August 31, 2020

RE: Project File Number, Brown and Jackson, SE-20-00003

Our written comments submitted are in regard to Washington State Environmental Policy Act (SEPA), Chapter 43.21C RCW, and Kittitas County Grading Permit public notice Brown and Jackson, SE-20-00003, dated, Monday, August 17, 2020. It is of our understanding that Kittitas County is acting as SEPA Lead Agency for the proposed project and proposed SEPA project actions and that Kittitas County is reviewing Brown and Jackson's June 11, 2020 Kittitas County, Department of Public Works, Grading Permit Application. However, based on review of the documents we understand we are commenting on the project as a whole, including, but not limited to, SEPA determination for Washington State Department of Ecology's General Permit for Biosolids Management.

**BROWN & JACKSON**  
 Land Application Site  
 Preliminary  
 Site Map  
 Kittitas County  
 Washington

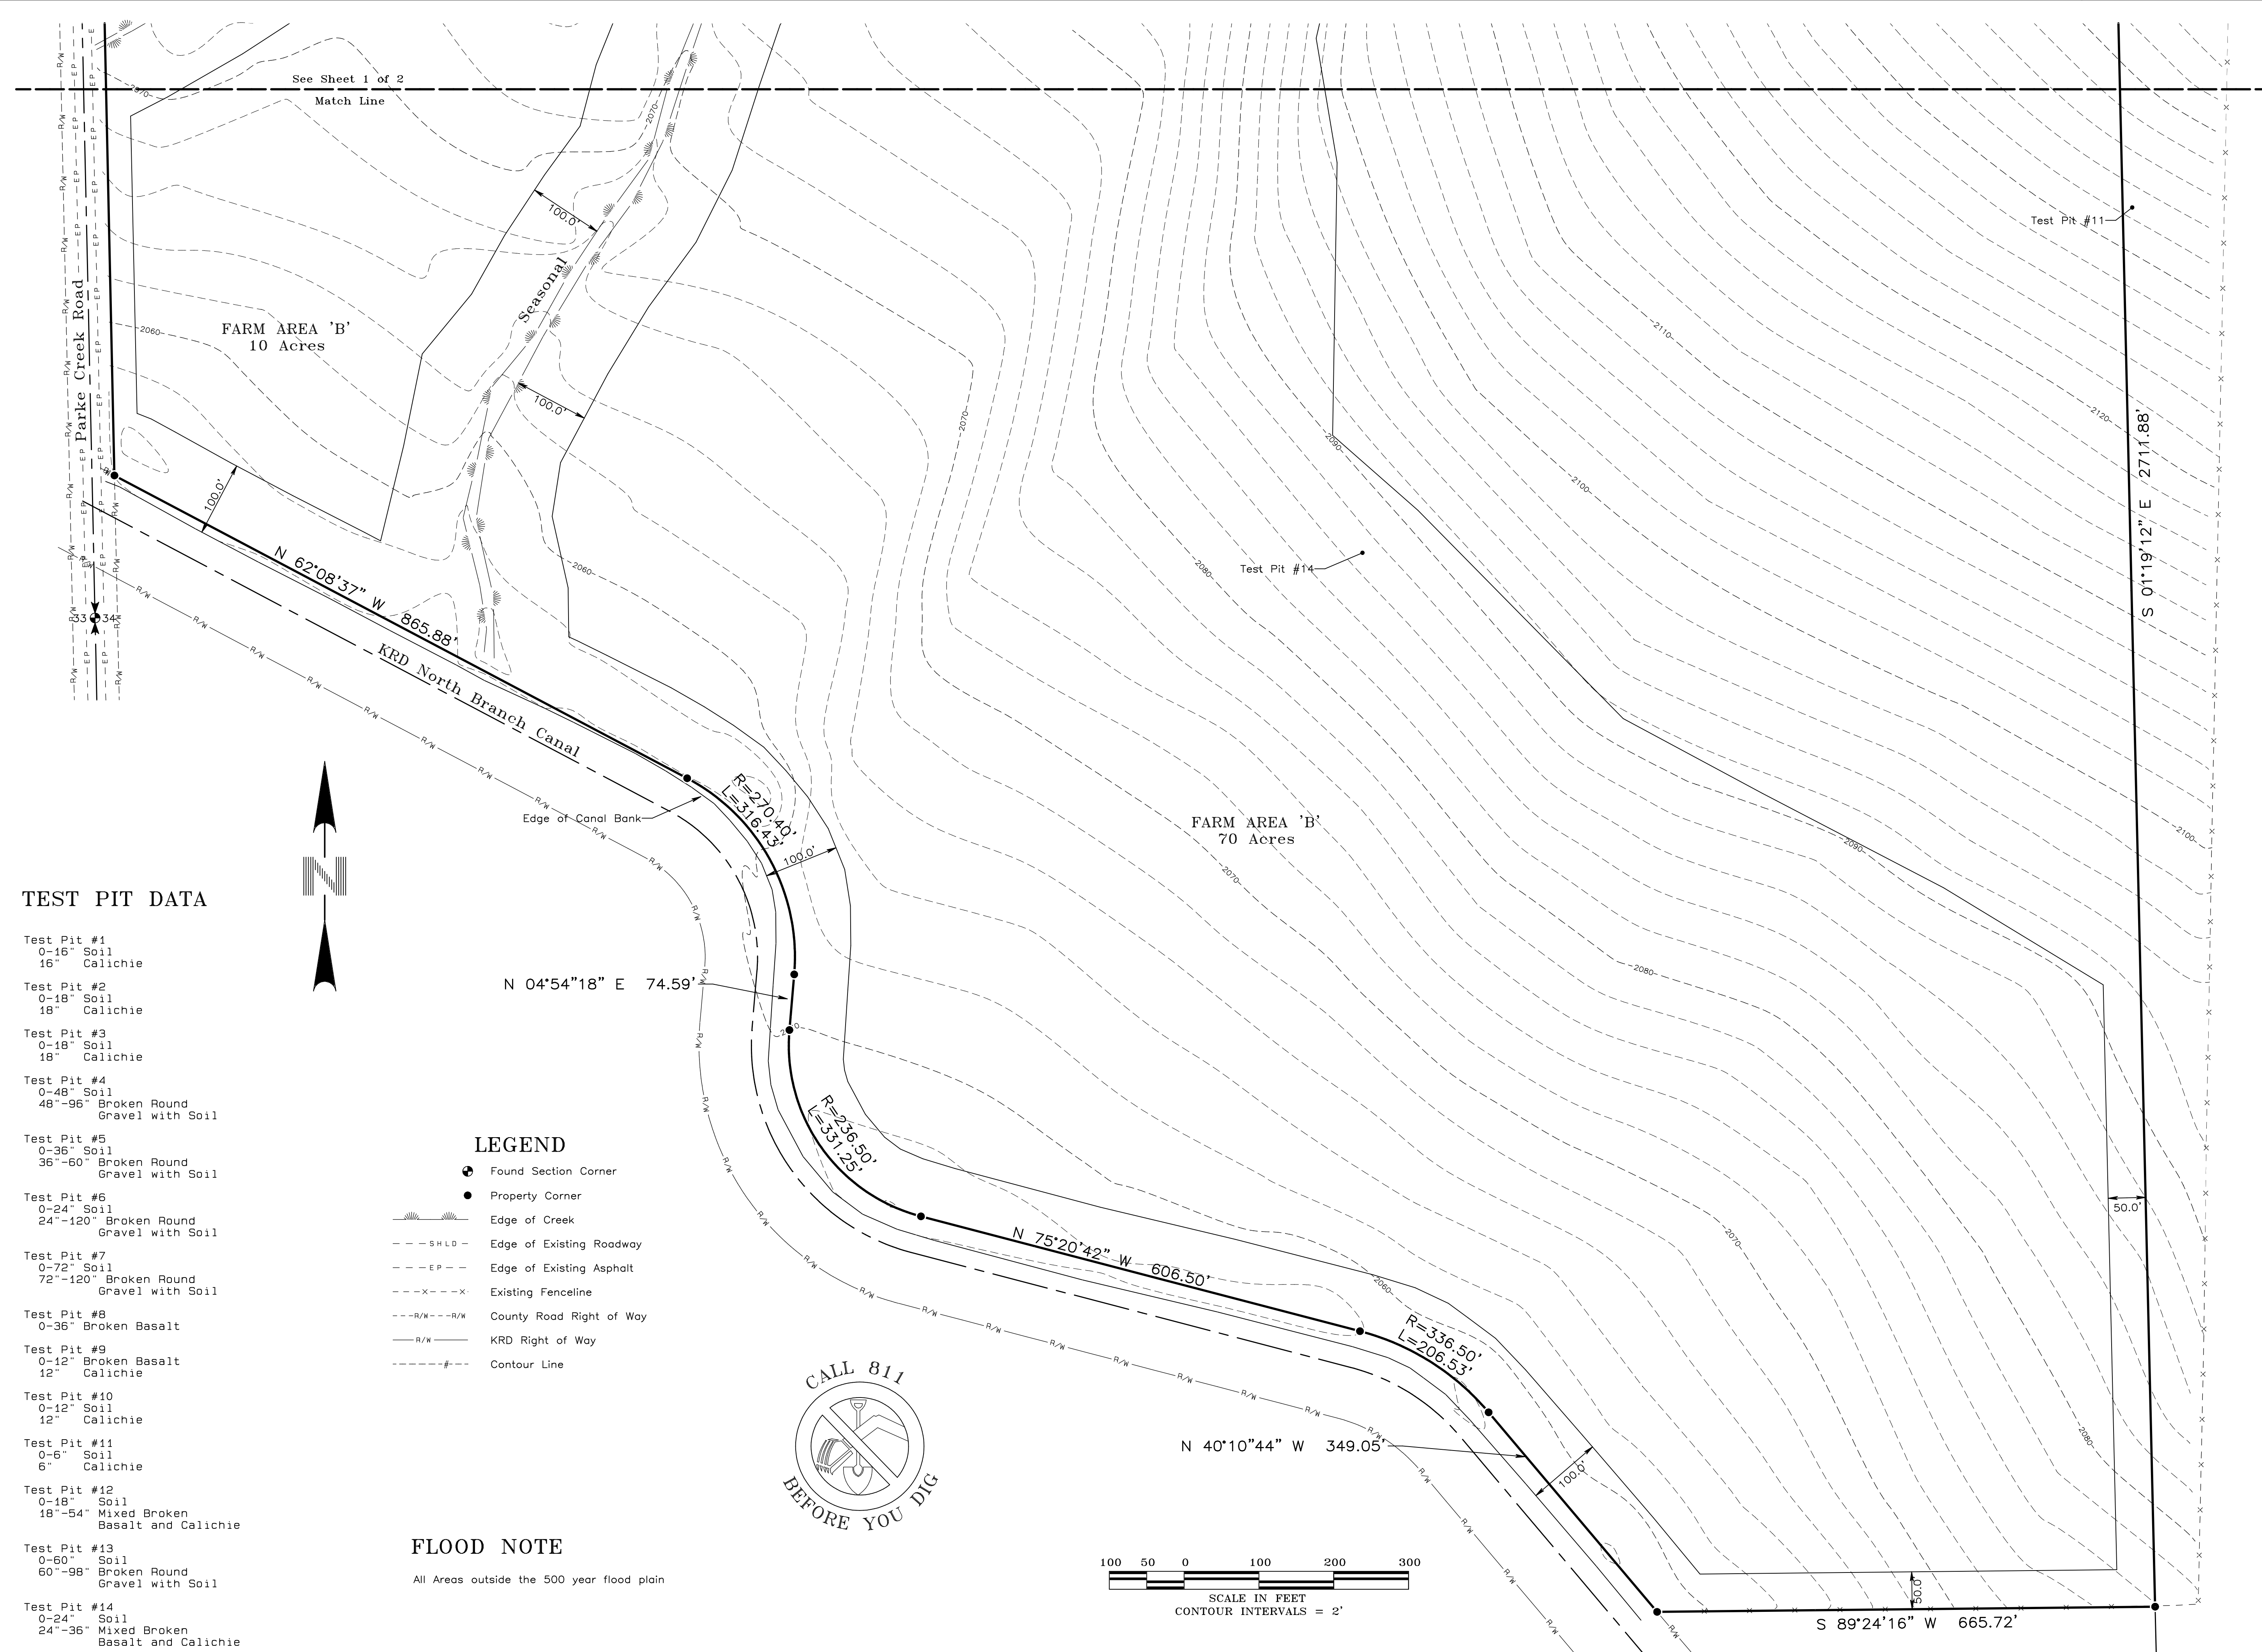
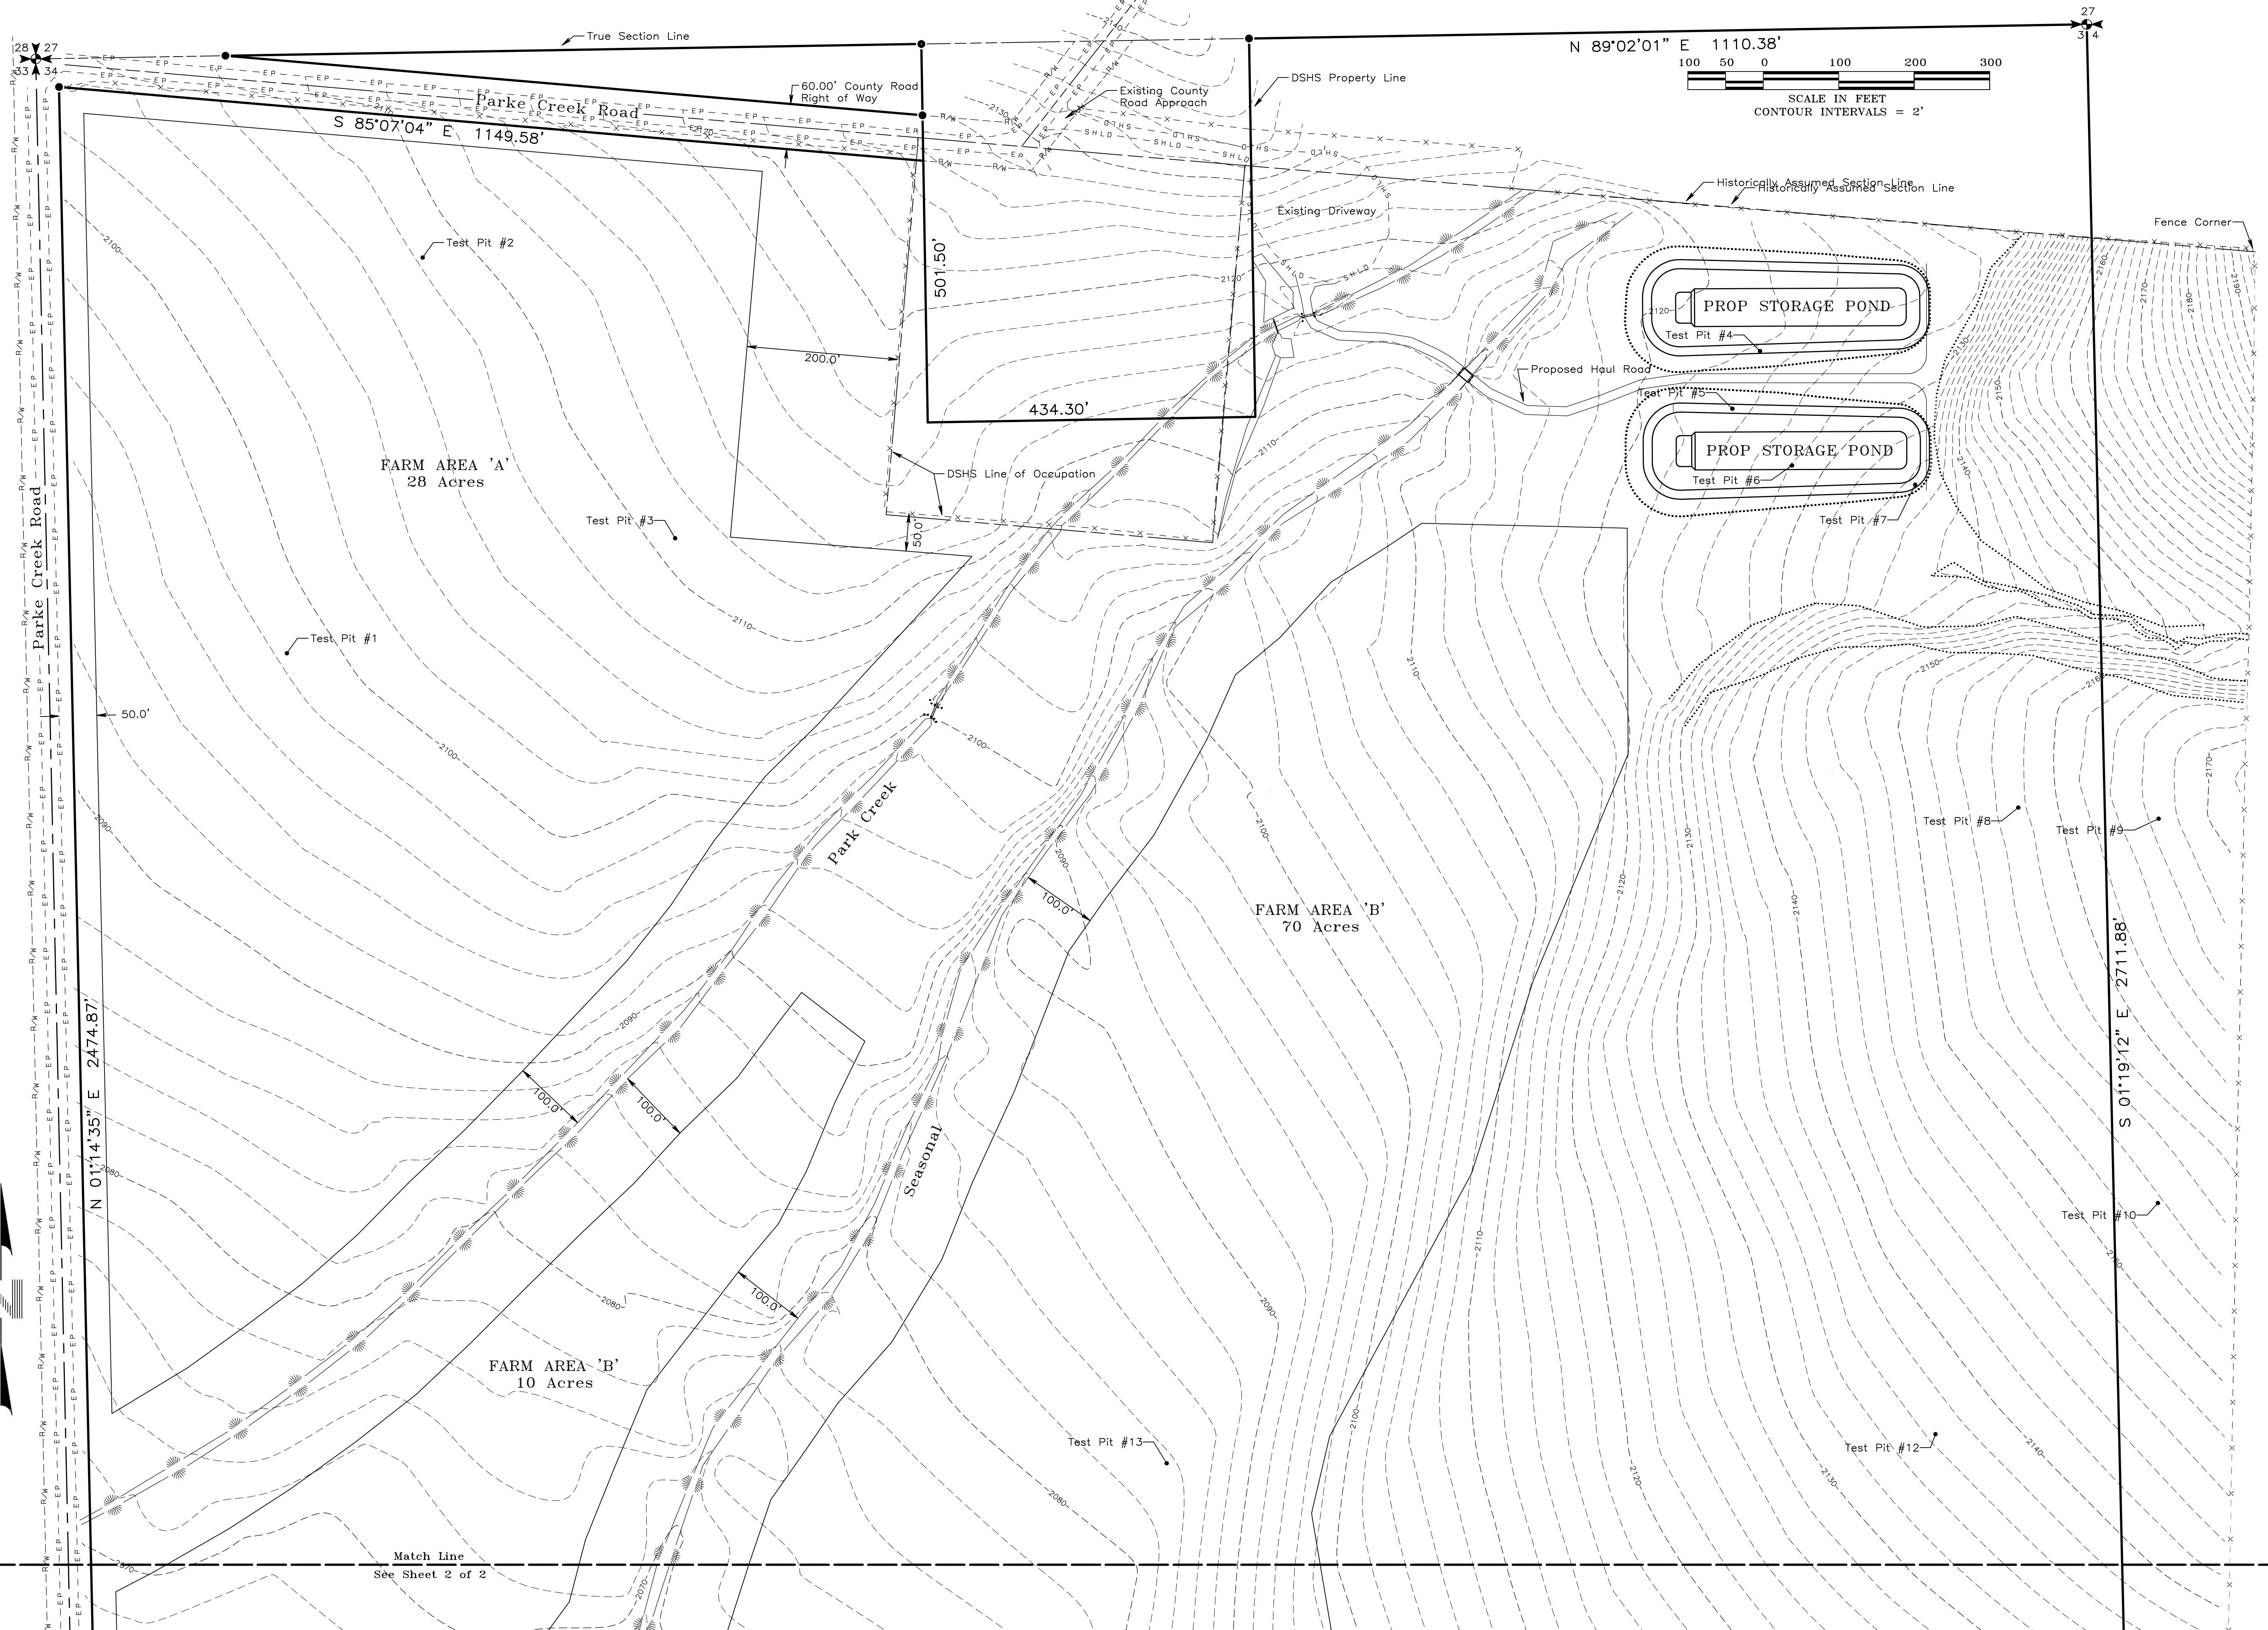
A.12.: Included Preliminary Site Plan does not appear to locate features, such as streams and irrigation ditches accurately. Included map in the July 30, 2020 Western Pacific Engineering and Survey document improperly characterizes Parke Creek’s location with respect to the fields and proposed storage ponds. Parke Creek is the water body flowing from the north to south on the eastern-center portion of the site. The irrigation ditch, locally known as Parke Creek Ditch, flows from the east to the west across the site conveying irrigation and stock water to farms and ranches several miles downstream of the site. Please update maps and labeling.

A.1.: Parke Creek Ditch flows east to west diagonally across the project site. Parke Creek flows north to south across the project site. KRD North Branch Canal immediately abuts the project site to the south. 3 surface water bodies, total. Please update.

B.1. Answer provided is incorrect. The Parke Creek Ditch and KRD North Branch Canal are either within or immediately adjacent to the project. Describe how any runoff or over application of septage will directly impact 1,000's of acres of highly valuable farmland and crops.

Corrections to the map are included in Attachment 1.
